Application Reference: 2025/0254

Site Address: 3 Rydal Close, Penistone, Barnsley, S36 8HN

This application seeks full planning permission for a first-floor rear extension, replace rear detached single garage with double garage, convert integrated front garage into habitable area, widen front drive and alterations to fenestration and doors to dwelling.

Drawing Title: Ground & First Floor - PROPOSED

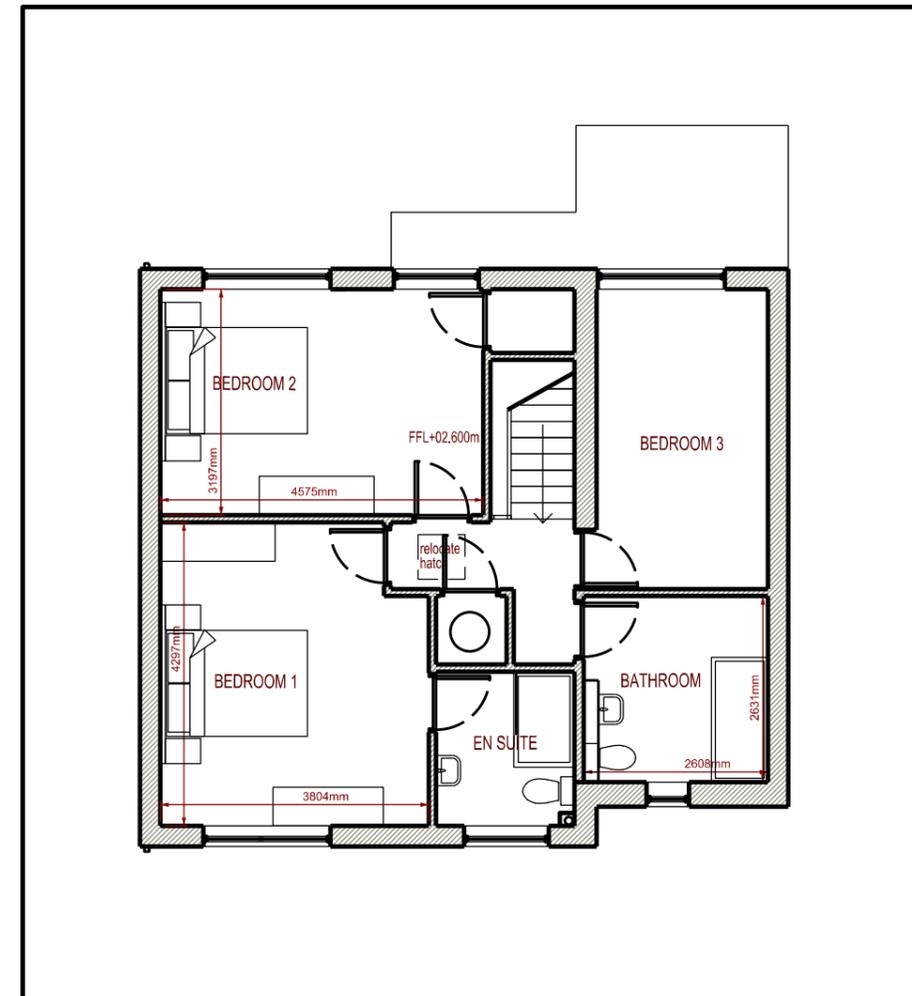
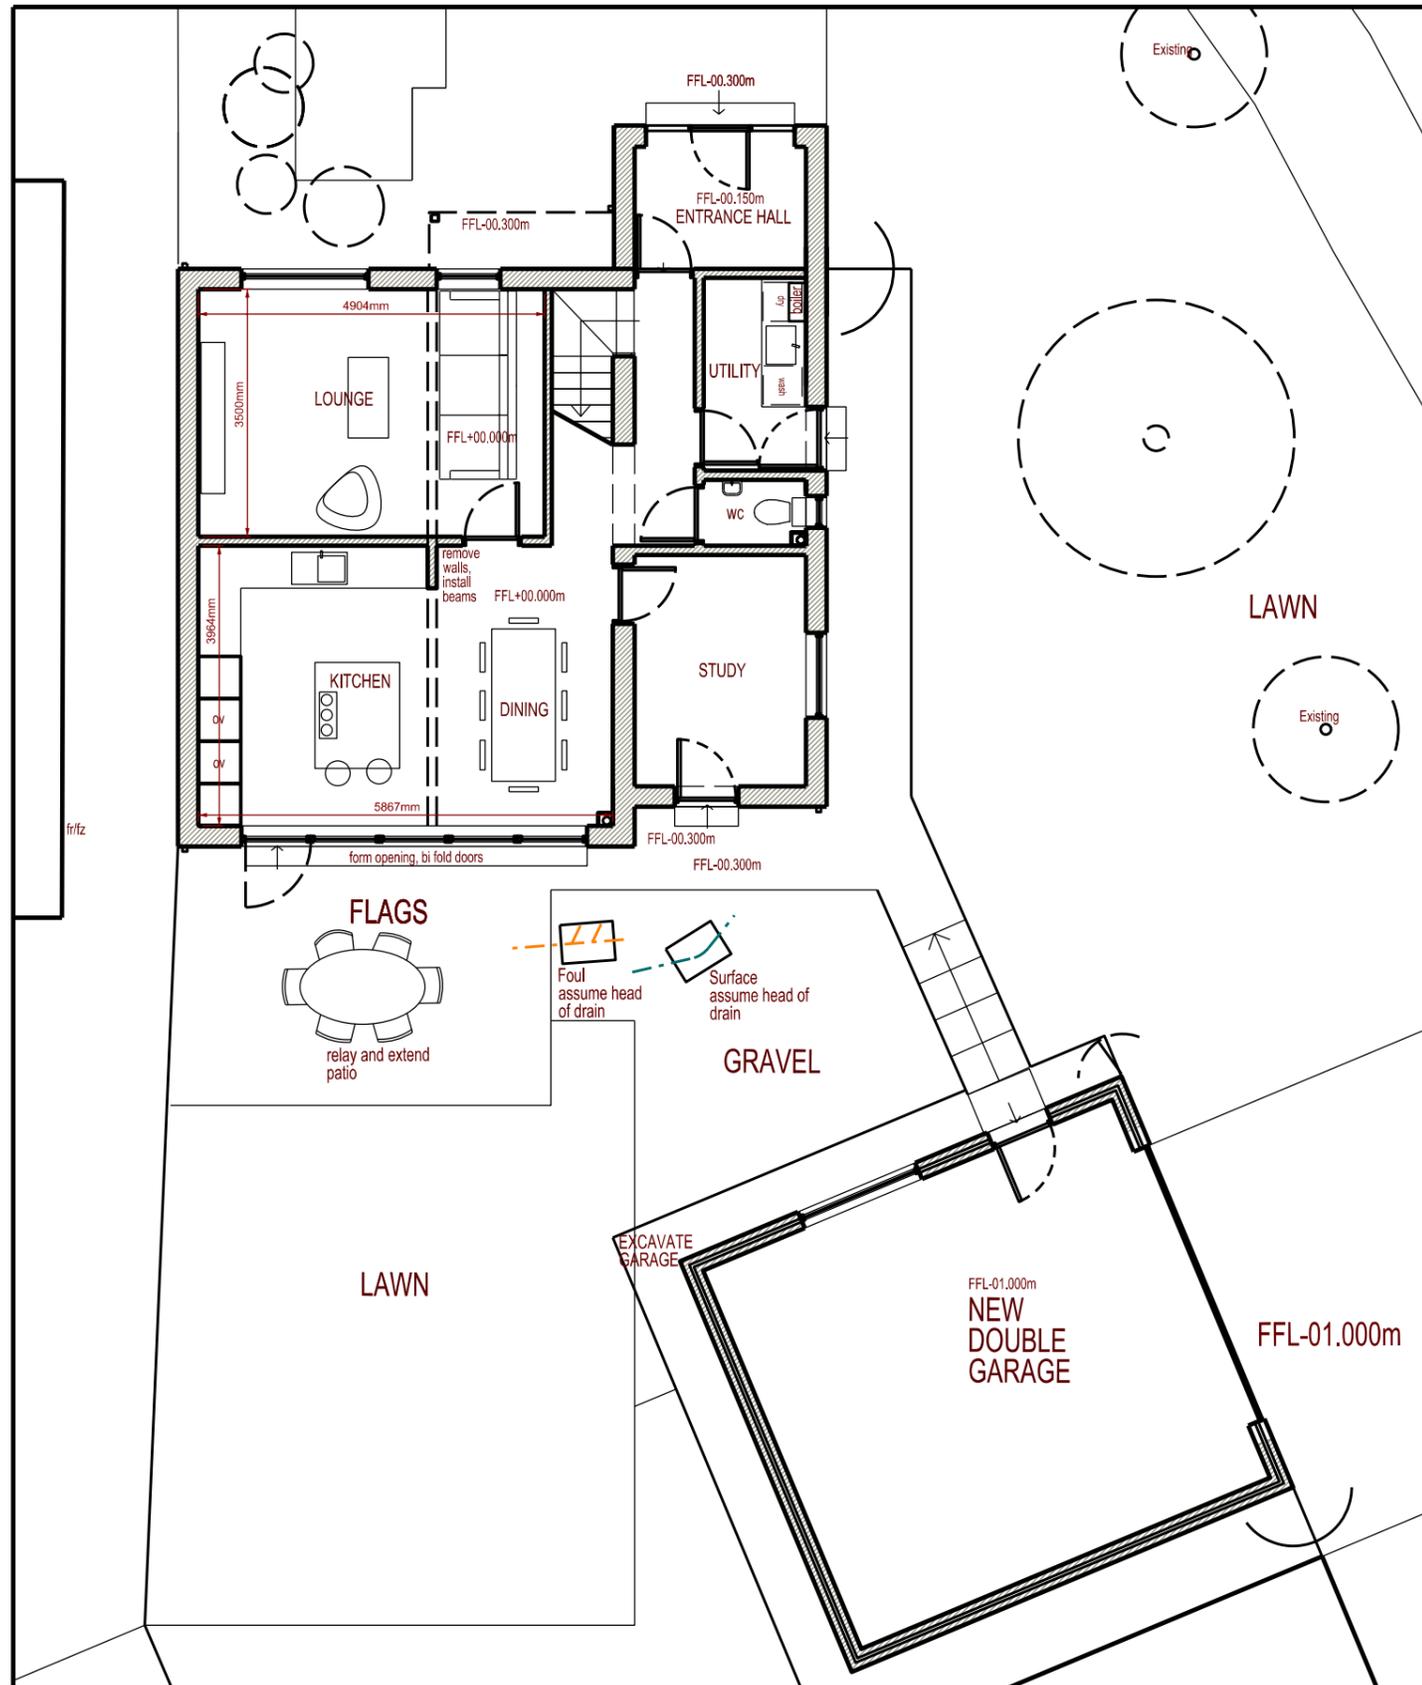
The integrated garage conversion, creating new living accommodation within the current garage may be permissible through permitted development rights but as it is included within the application it must be assessed. Building control regulations would mandate the internal requirements such as insulation but planning reviews the exterior aspect of the proposal. In this instance, the insertion of a new front entrance door with side glazed panels, in replacement of the existing garage door is proposed. With limited new brickwork required for the infilling of the former garage door, the visual impact would be reduced to having a limited effect on the front elevation of the dwelling. Because of the relocation of the front door, the existing front door is proposed to be converted into a window and bricked up below, again with minimal brickwork, the impacted would again be limited.

A small bin storage area is proposed in front of the former front entrance door. Whilst structures are not generally allowable beyond the front elevation of a dwelling, the proposed store would sit under the existing porch, which would otherwise be redundant due to relocation of the front door. The proposed height of the store is 1.15m, which is just more than the 1m size of fences allowable through permitted development within a front garden. With the porch roof existing, the bin store is akin to a fence, and with a long driveway, the small height differential would cause limited harm to the character of the house or the street scene,

- Clarification of the height of the patio, the identification of the bin store was requested.
- An additional plan was optionally provided to illustrate the proposed garage in relation to the neighbouring dwelling, which helped assess its potential impact.
- Amended plans with a slightly altered garage door and a larger projection into the applicant's rear garden were submitted.

Drawing Title: Elevations - PROPOSED

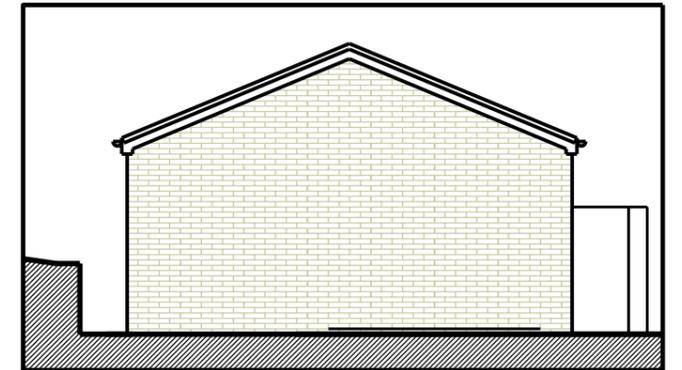
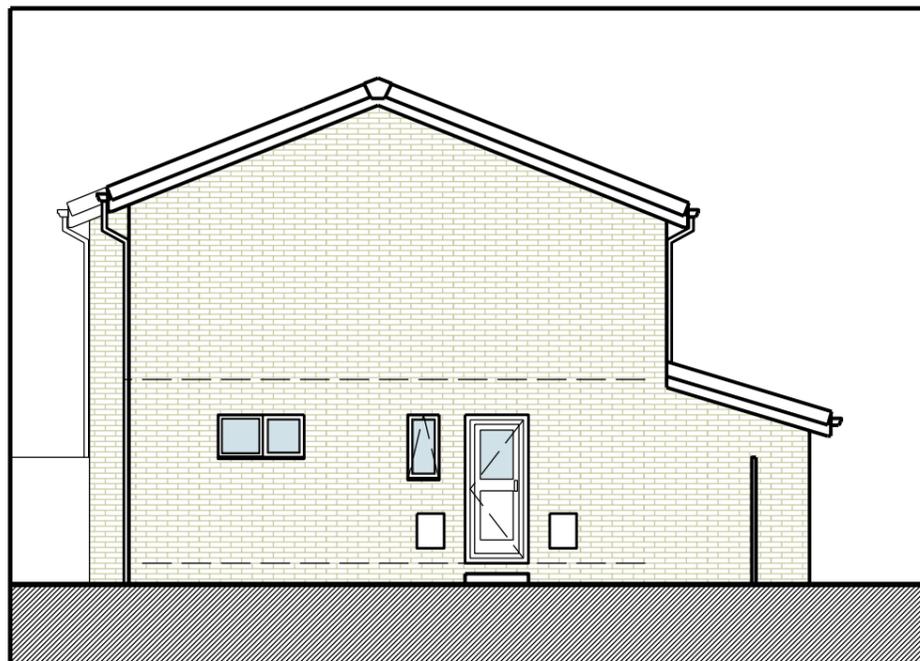
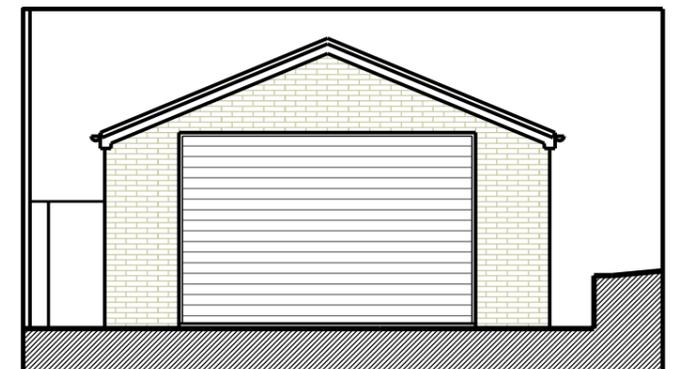
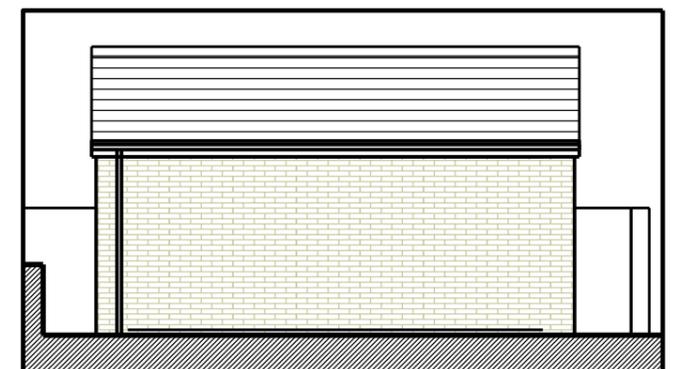
The proposal does not fully comply with SPD guidance for two storey extensions, but on this specific instance, the requirement for a step down of the roof over the first-floor extension would undoubtedly cause an unbalance with the existing roofline, and would only be visible on the rear elevation so would not impact the existing front elevation which is the most prominent elevation when viewed from the road.. There is an existing setback to the ground floor section of the rear elevation, where the proposed first-floor extension would be created above. The first-floor addition would replicate the setback, giving the impression of a later addition to the original dwelling. Because of age differences in brick, even with materials of a similar appearance being used, there would potentially be some unavoidable visible bonding of old and new brickwork. Overall, with the modest size of the proposal, the impact on the design and character of the original dwelling would only be considered as modest.

Whilst arguably the existing old detached garage, which is situated adjacent to No1's two-story extension, is out of character with both No1 and the application dwelling, and after approximately 40 years may be considered as unsuitable in both design and purpose for current larger vehicles; the proposed changes, particularly the roof height would undoubtedly have an

impact on the character of No1 and the broader street scene, but conversely minimal impact for the application dwelling. The existing height of the garage is approximately 2.48m, in comparison the proposed garage would have an approximate eaves height of 2.55m, and an overall ridge height, with a gable style roof of 4.08m. At a maximum height increase of around 1.6m, despite the sloped roof limiting the maximum height to the ridge, the scale of the proposal would still be considered to have a moderate impact on scale.

The design of the garage itself is OK but as with the proposed scale, it's the design of the garage and its impact, somewhat uniquely in this instance, on the character of neighbouring dwelling of No1 would be of foremost concern, with less impact expected in relation to the character of the application dwelling and broader street scene. Initially from a site visit and viewing the proposed garage in isolation of a street scene, it appeared that it would have a potentially significant impact on the visual amenity of No.1. Having reviewed the profile plan provided of the proposed garage adjacent to No.1, whilst there is some obvious contrast between the extended dwelling of No.1, which was completed after the construction of the applicant's garage, and the proposed garage, the difference does not appear to be as significant as it first appeared. There is disparity between the roof design of the garage and No.1, but requiring a side gable would expose a higher proportion of the maximum roof height compared to the proposed roof design and may require an increase in eaves height. When considering what may also be constructed through permitted development, if sited further away from the boundary with No1, it would be prudent to allow this proposal which in final consideration would appear to have a modest impact on the character of No1, and a limited impact on the character of the application dwelling and broader street scene.

Drawing Title: Site Plans - EXISTING & PROPOSED

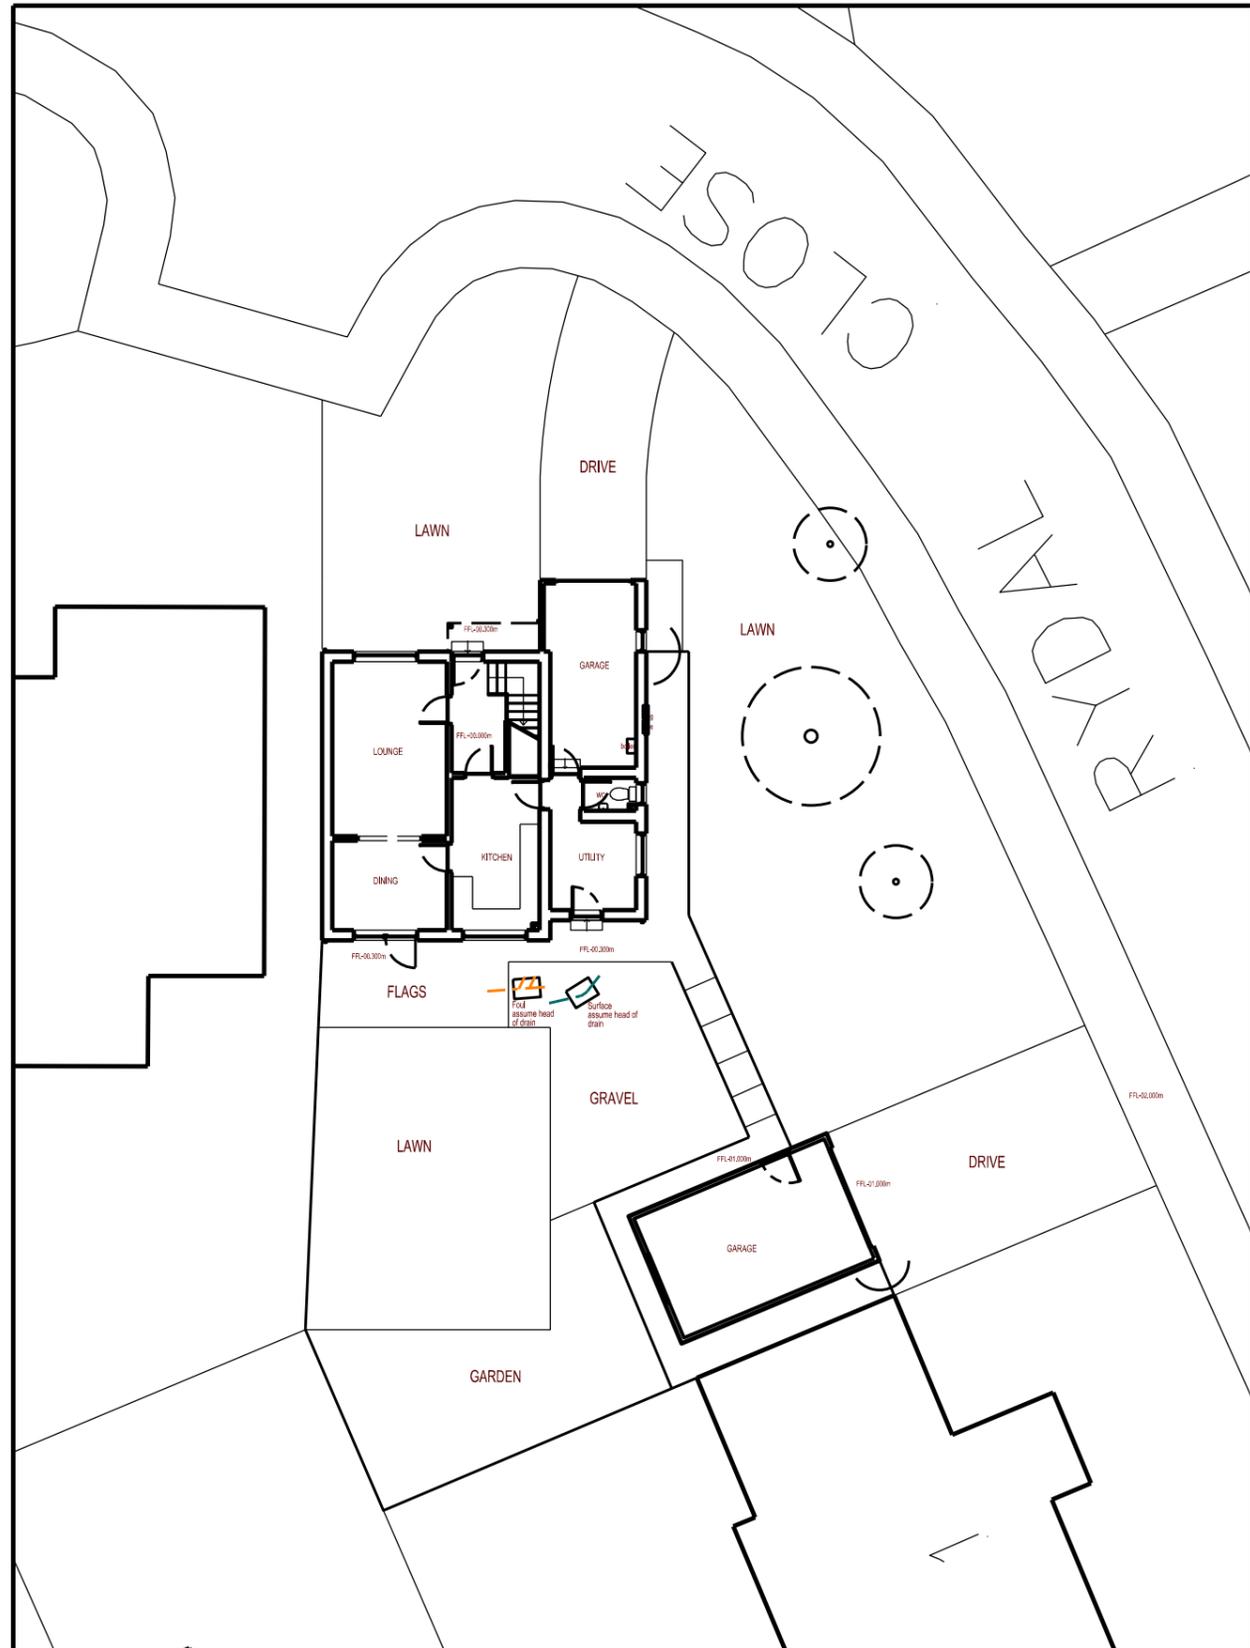
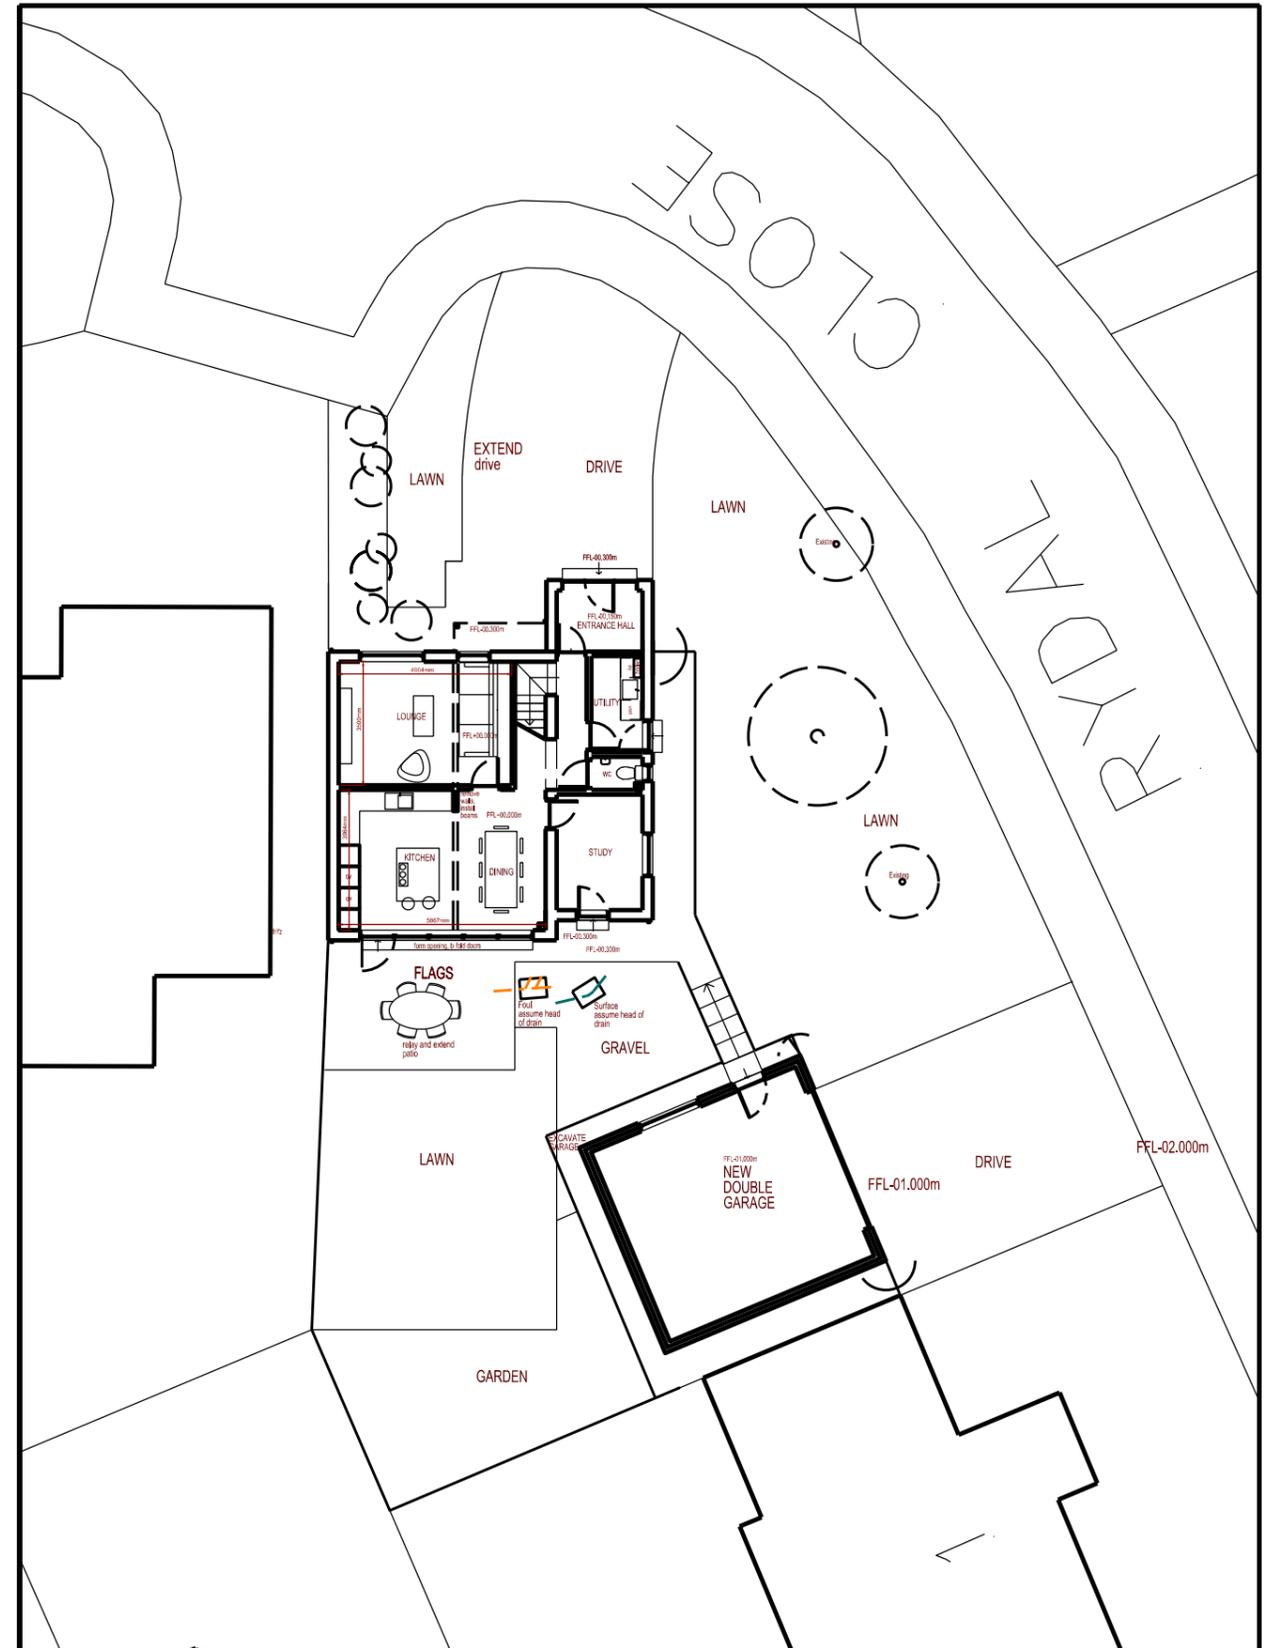
The proposed garage, whilst close to the neighbouring dwelling's own integrated garage and first floor extension would pose no more harm to their amenity than the long-established existing garage. Development of the garage extends the width and length of the garage into the existing curtilage of the application dwelling, but it would not be expected to have any impact on neighbouring amenity. Whilst the proposed roof is higher, the roof would broadly only overshadow the side elevation of No1's extension and the applicant's garden. Therefore, there would be little or no impact on neighbouring amenity.

existing detached garage, along with both individual areas of driveway each offer adequate space for a single parking space of current policy requirements of 2.5m by 5m. Consequently, with or without the current or proposed detached garage, two parking spaces are available within the curtilage of the dwelling and the proposals would not otherwise affect highway safety, resulting in little or no impact on parking provision or highway safety.
